Fw: Urgent Objection to retrospective planning

79358/APP/2026/1423 Accepted	2 CHARTWELL ROAD NORTHWOOD
--	-------------------------------

I am writing to object to the retrospective planning application 79358/APP/2026/1423 at 2 Chartwell Road for the following material planning :

PROPOSED GROUND FLOOR PLAN

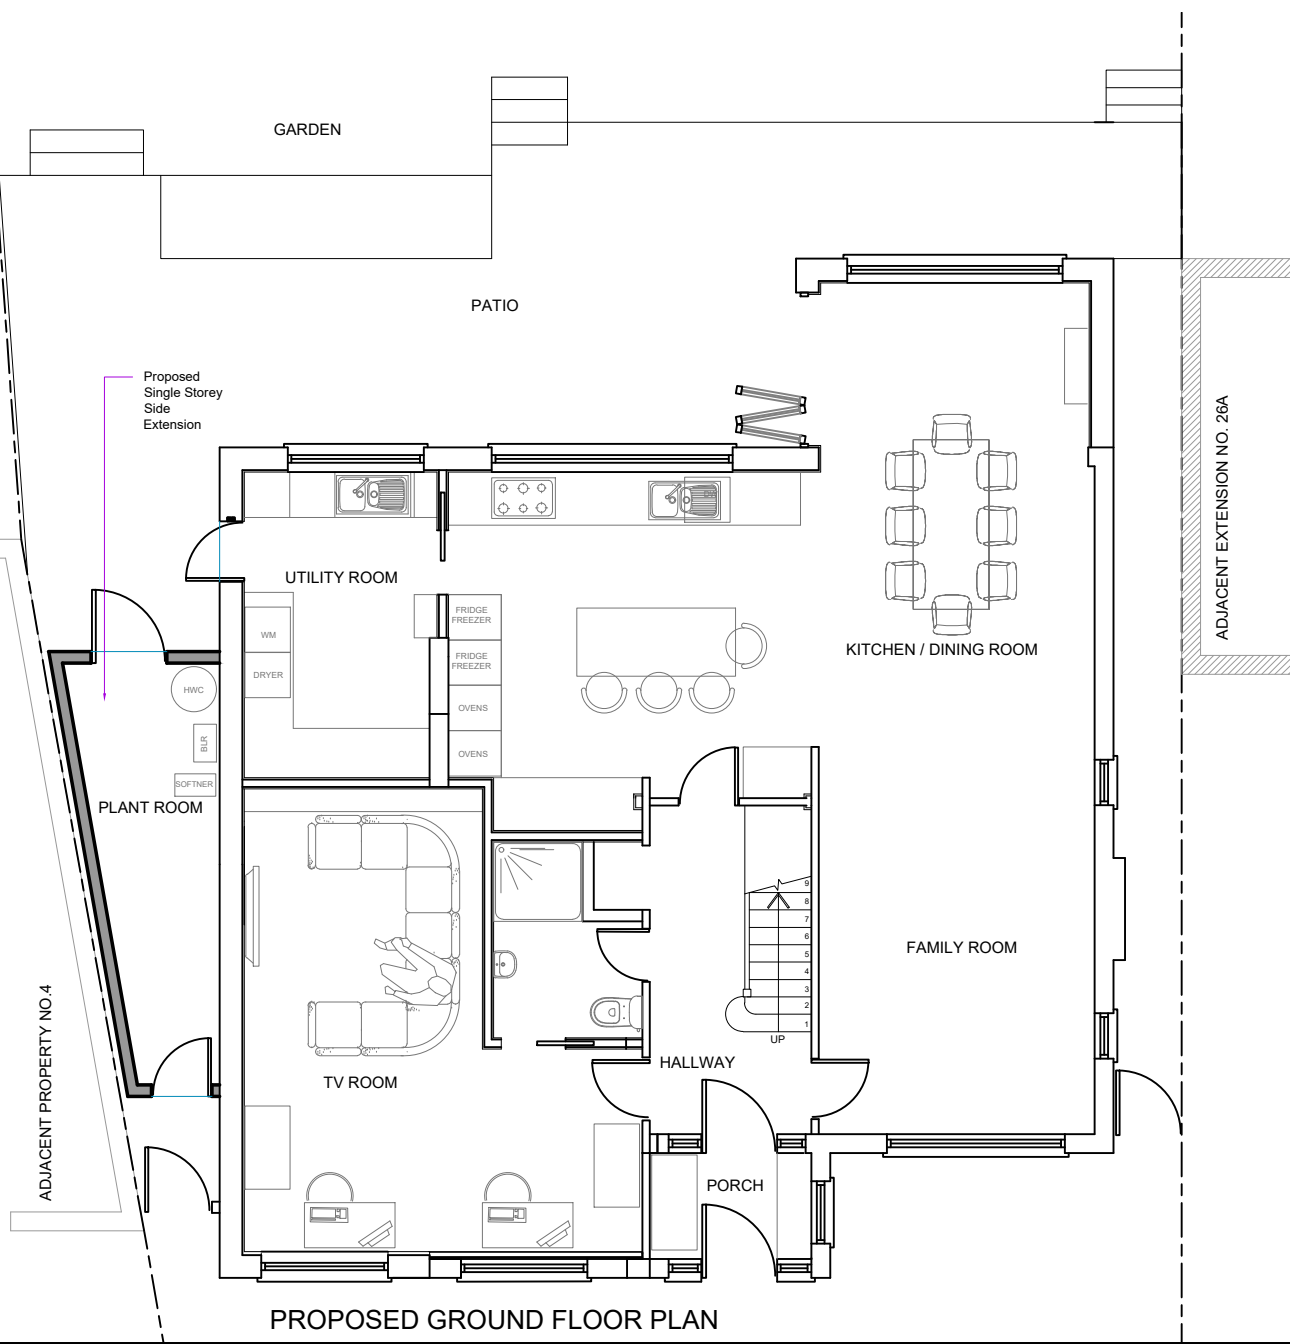
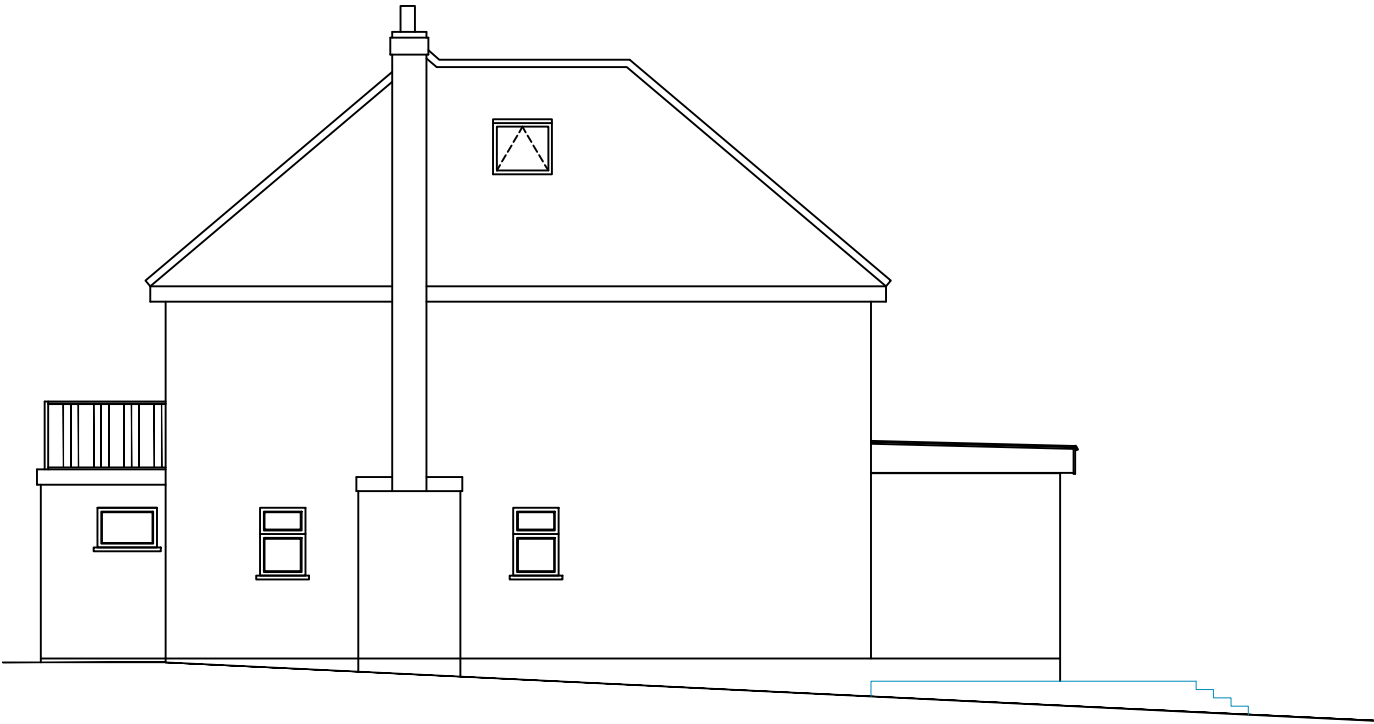
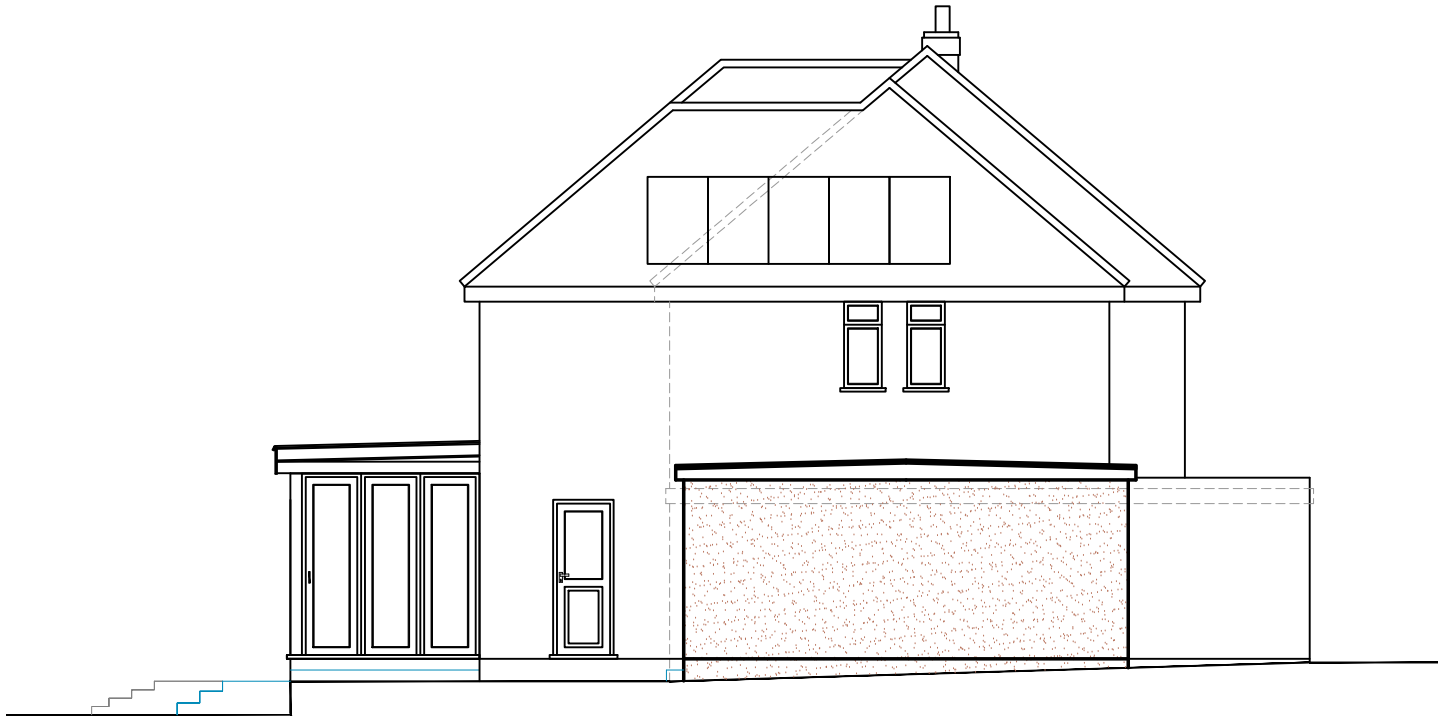
1)Unacceptable Amenity and Maintenance Impact: By placing this structure very close to our property wall, the applicant has effectively compromised our ability to access, inspect, and maintain the fabric of my own building, creating long-term structural and maintenance detriment

A small gap is completely inaccessible. It is too narrow for a human arm, a ladder, or maintenance tools.

They have permanently blocked the ability to inspect, paint, point, or repair the brickwork in that wall .

Leaves litter and rain will fall down this gap and get permanently trapped. This will inevitably bridge moisture straight into our wall, creating structural penetrating damp inside our property

The structure is built to house a boiler. Due to its extreme proximity to our wall, there are significant concerns regarding the safe termination of the boiler flue. A 100-200mm gap is completely inaccessible.

3) We were told they didn't dig for foundation. "No Foundation" Structure is structurally unsafe. A brick or timber structure built to hold a heavy boiler, water pipes, and flues that sits on the surface of the ground without proper foundations is a major structural hazard. This can cause dampness to bridge across into our property or apply physical structural pressure.
